Application: WA/31/22/DOC
Location: Land To East Of Fontwell Racecourse Fontwell Avenue Eastergate BN18 0SW
Proposal: Approval of details reserved by condition imposed under ref WA/48/19/RES relating to Condition No 9 - external lighting.

Summary

Proposed floodlighting

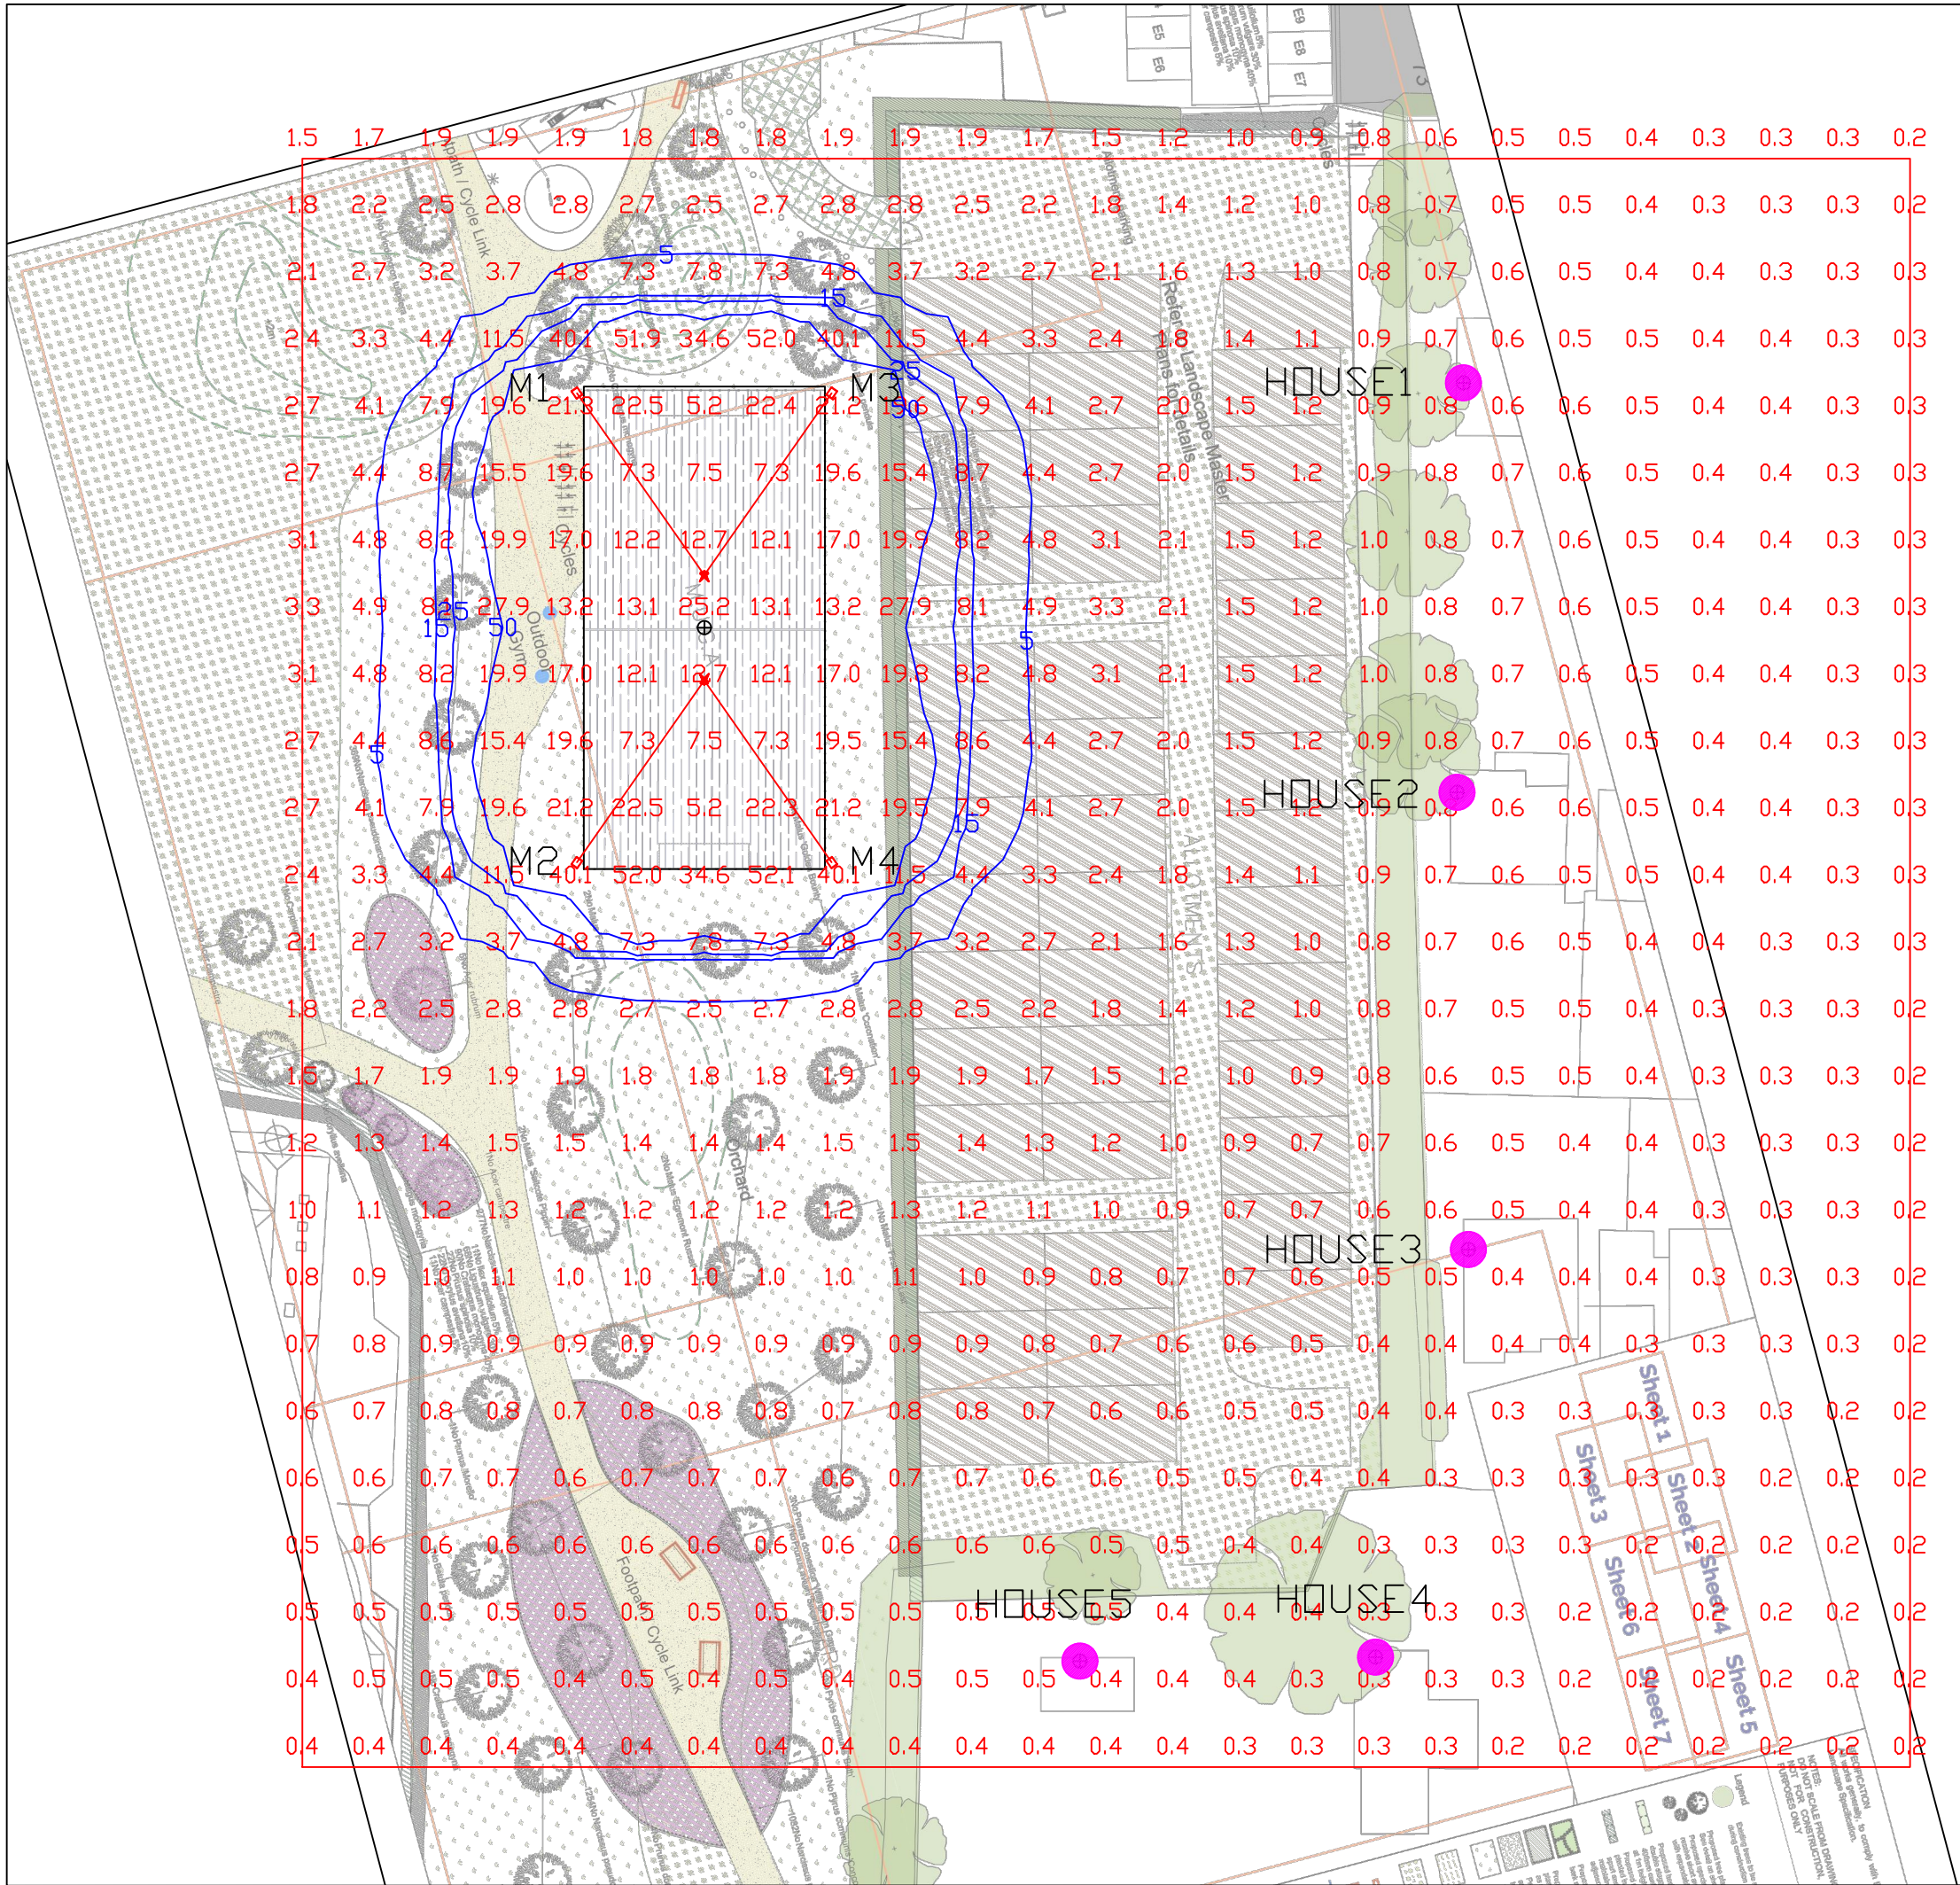
However we seek reassurance that shields will be fitted to the new floodlighting to avoid unnecessary light spillage onto any features used by foraging or commuting bats.

Subject to shields being secured as part of the lighting design and implementation of the approved scheme in full, we recommend discharge of Condition 9.
